August 2, 2021
Ron Bohannon
Tierra West, LLC
5571 Midway Park Place, NE
Albuquerque, NM 87109

**Re: M&B Investments LTD Co. - 7200 Bluewater NW
Erosion and Sediment Control Plan
Engineer's Stamp Date Missing (K10E060)**

ENGINEER'S SEAL	7200 BLUEWATER RD ALBUQUERQUE, NM	DRAWN BY pm
	EROSION CONTROL PLAN	DATE 7-20-21
		DRAWING 2020056-SWPPP
	TIERRA WEST, LLC 5571 MIDWAY PARK PL NE ALBUQUERQUE, NEW MEXICO 87109 (505) 858-3100 www.tierrawestllc.com	SHEET # SW-1
RONALD R. BOHANNAN P.E. #7868		JOB # 2020056

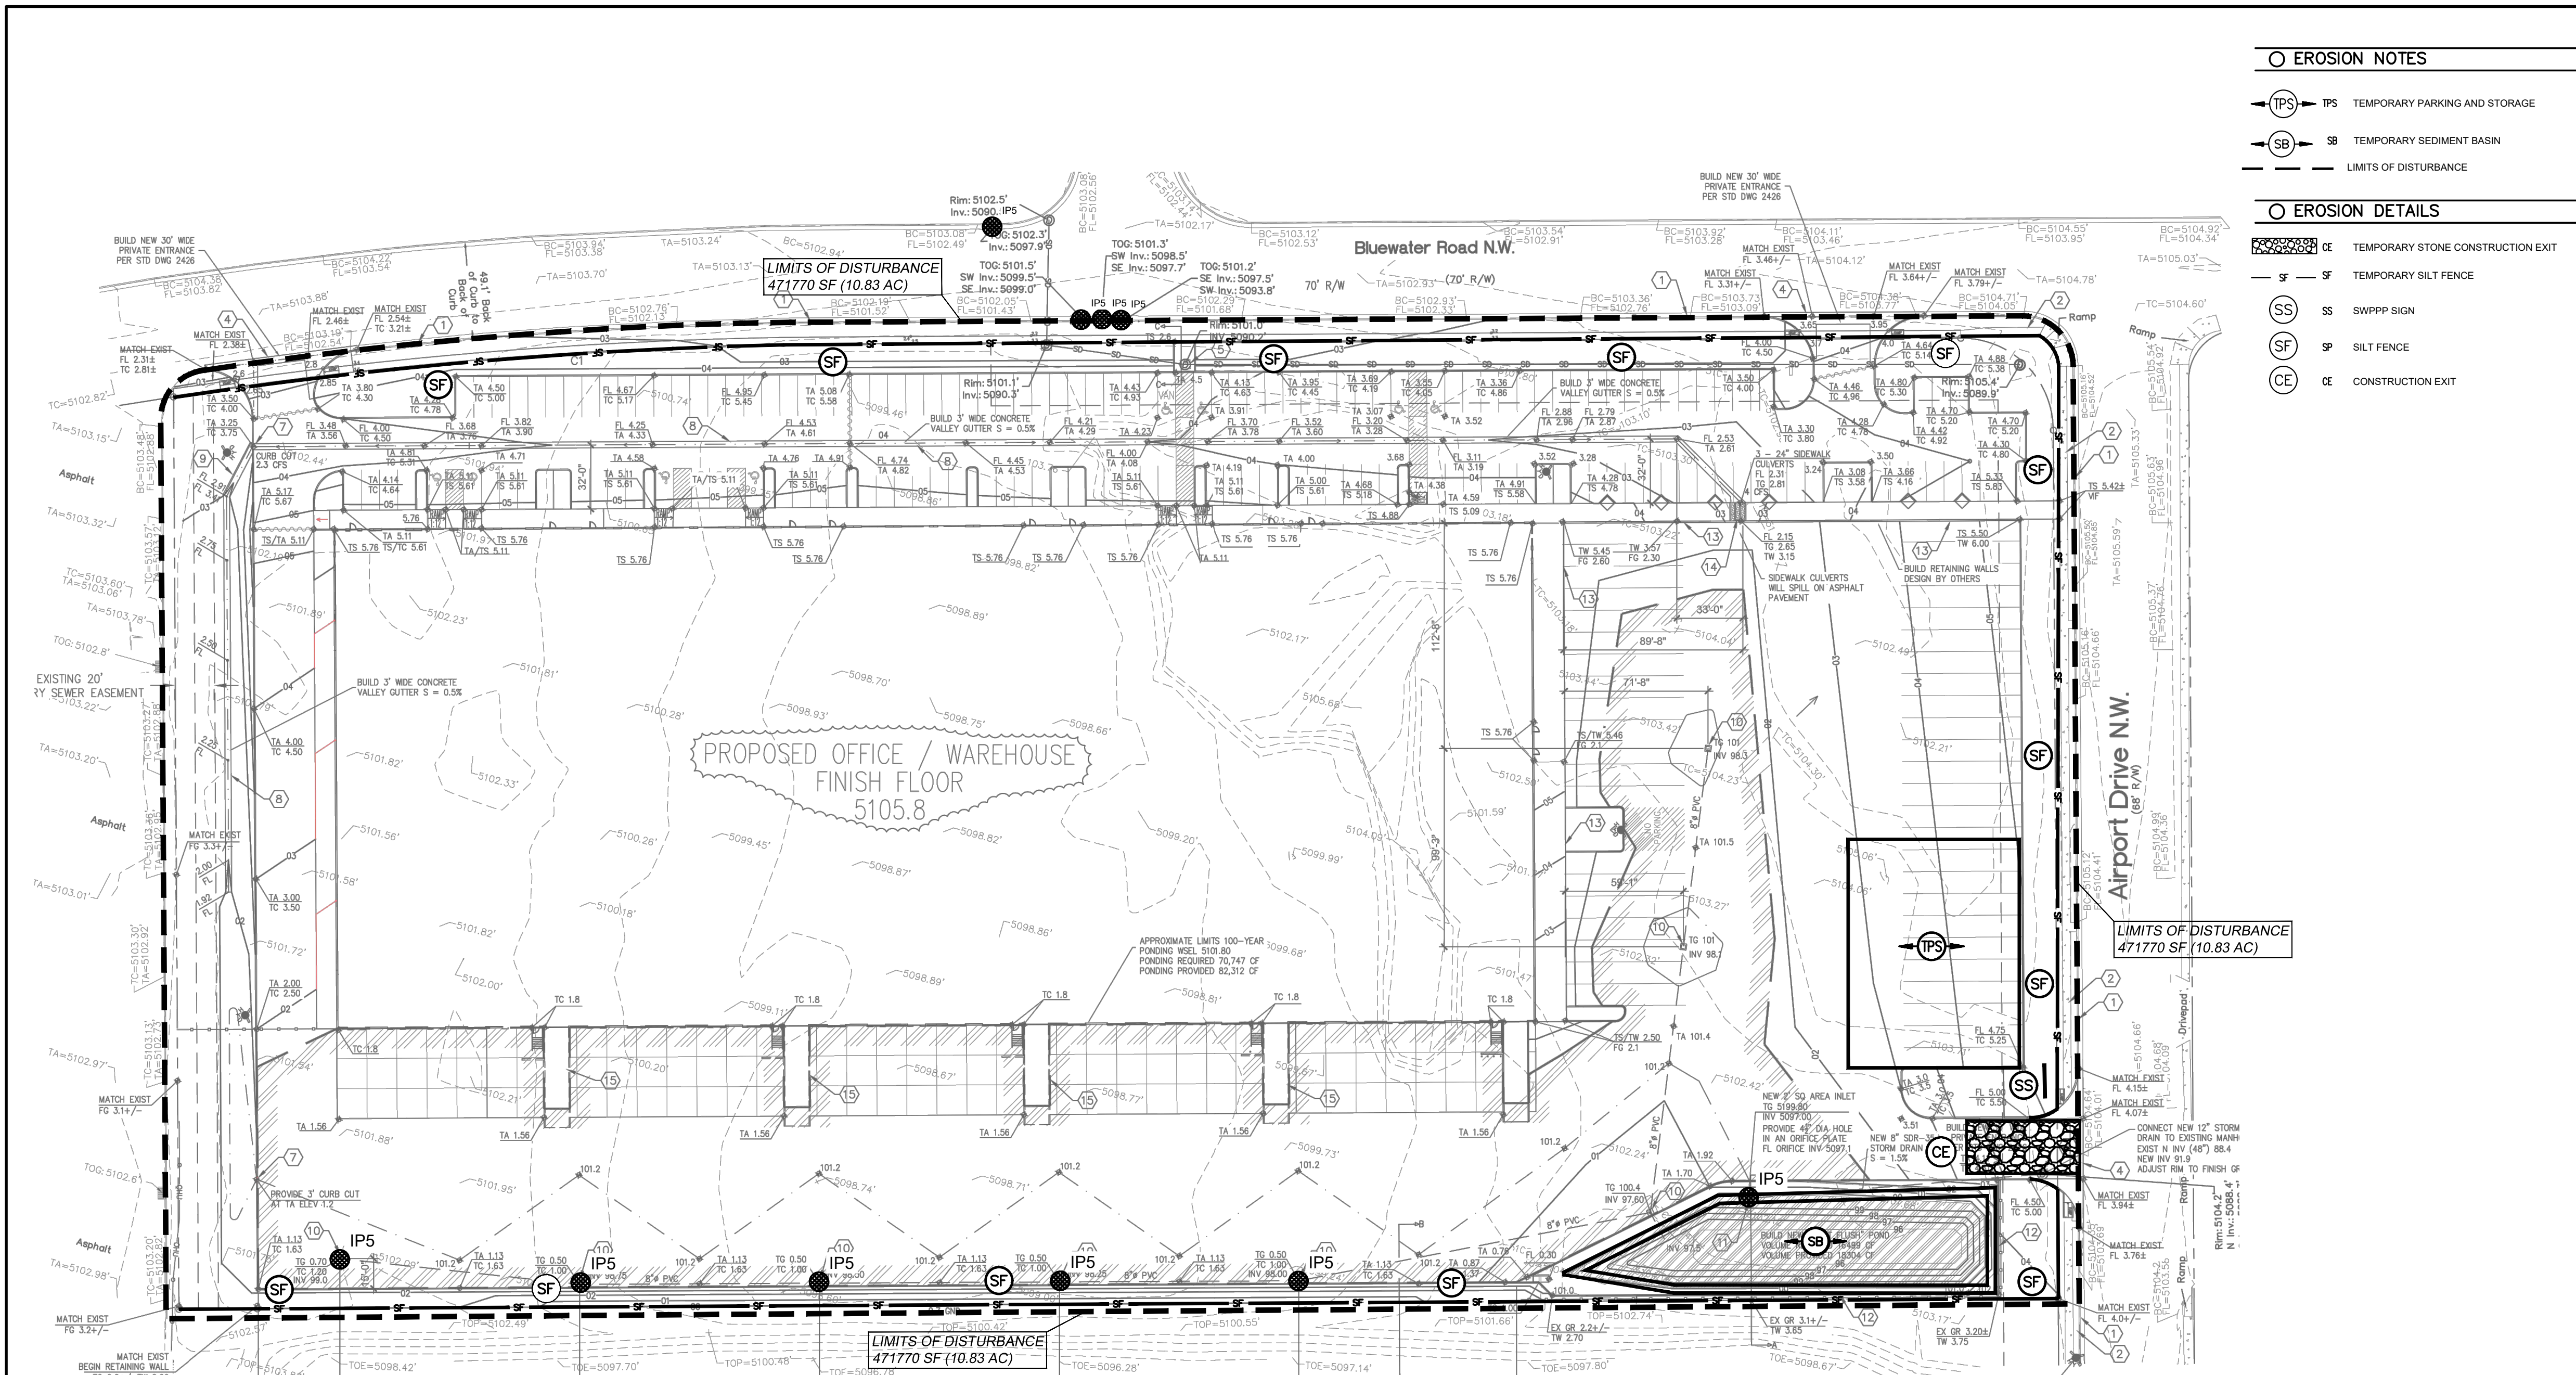
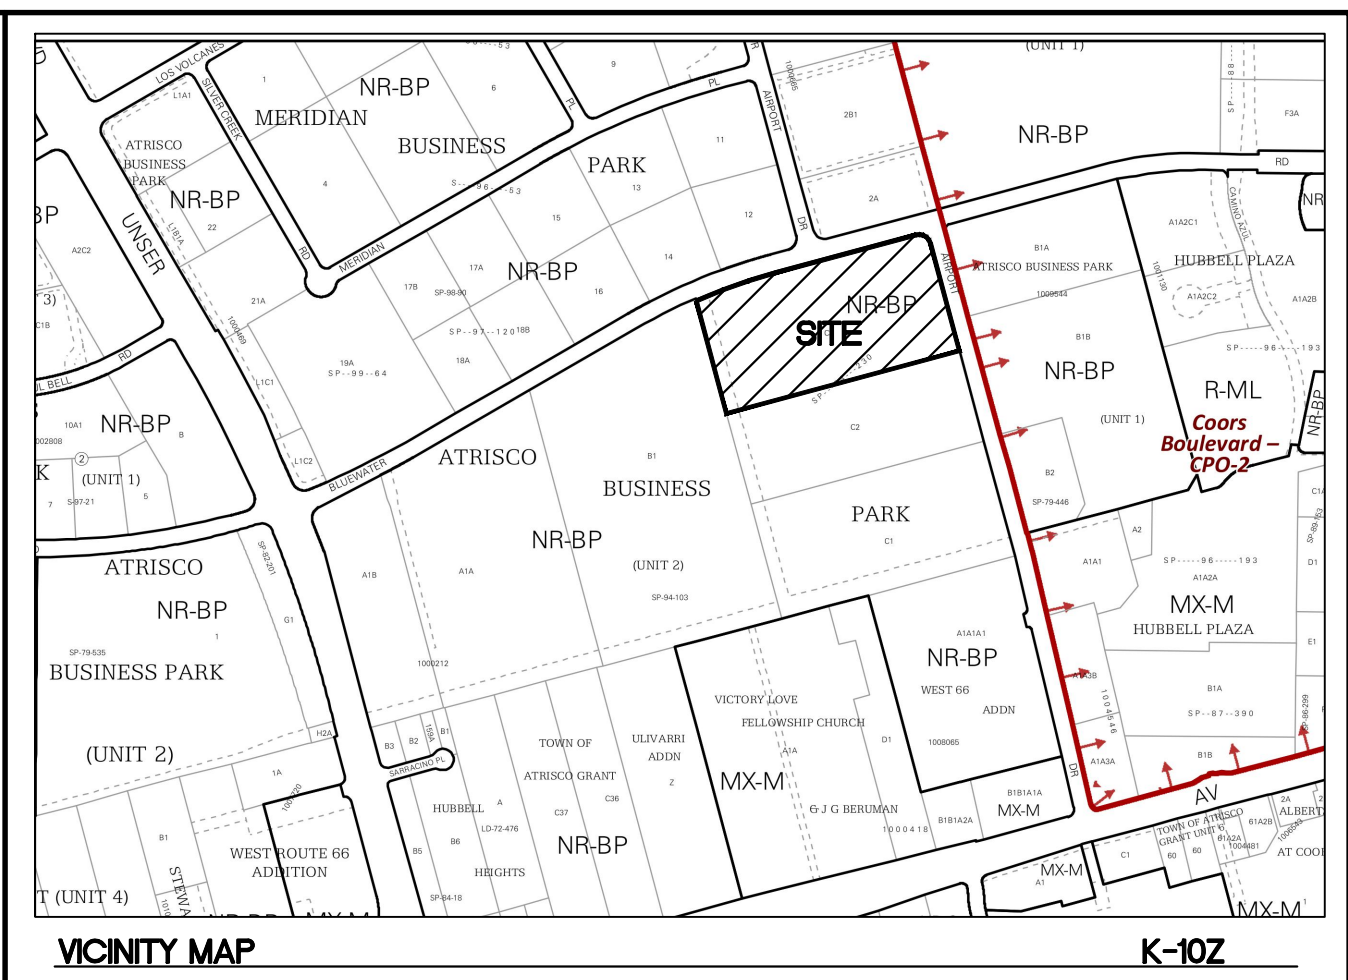
- ~~1. The limits of disturbance has been shown on sheet SW-1.~~
2. I can't tell the difference between building, sidewalk, asphalt and dirt on the ESC Plan. These structures must be clearly identified in the SWPPP per CGP 7.2.4.b.v. The same information is required in the ESC Application. You may include a copy of the Site Plan in both the SWPPP and in the ESC Application to address this requirement.

- ~~3. Undisturbed and pre construction ground cover is described on sheet SW-1.~~
4. Operator #1 on sheet SW-1 is "Brunacini Development Ltd Co" which does not agree with the Operator permitted by NMR1003UT "GA Brunacini Construction Co. Inc." and neither agree with the property owner of record "M&B Investments LTD Co." The latter two seem to identify the Contractor and the Property Owner both of whom need an NIO and both should be identified on sheet SW-1 along with the area of control of each.

5. This site has been in operation now for three months so the four SWQ Team members required by CGP 7.2.2 should be clearly understood and should already be well documented in the SWPPP. Identify the following team members on the ESC Plan sheet SW-1 and provide proof of training certificates.

- d. Personnel who are responsible for taking corrective actions as required in Part 5.
6. The "Nature and Extent of Construction Activities" on sheet SW-2 doesn't include the building or landscaping. The Schedule on sheet SW-1 also omits the building and the landscaping and talks about onsite roadway and installation of additional silt fence to

keep sediment out of onsite roadways which seems to apply to a totally different project. The description of Construction Support Activities may be omitted unless those areas of land-disturbance will occur off-site in which case the areas must be shown on the plan. Delete the paragraph that calls for annual inspections and replace it with the inspection frequency required by the CGP. Delete the sentence that says an NOI may be transferred since that is specifically prohibited by CGP Appendix I.12.3.

The site plan is attached to email response

A new NOI has been filed by property owner- Bluewater@Airport Opportunity Land, LLC

Updated on SW-1

Updated on SW-1 Training Certificates are attached to the email response

Updated on SW-1/SW-2
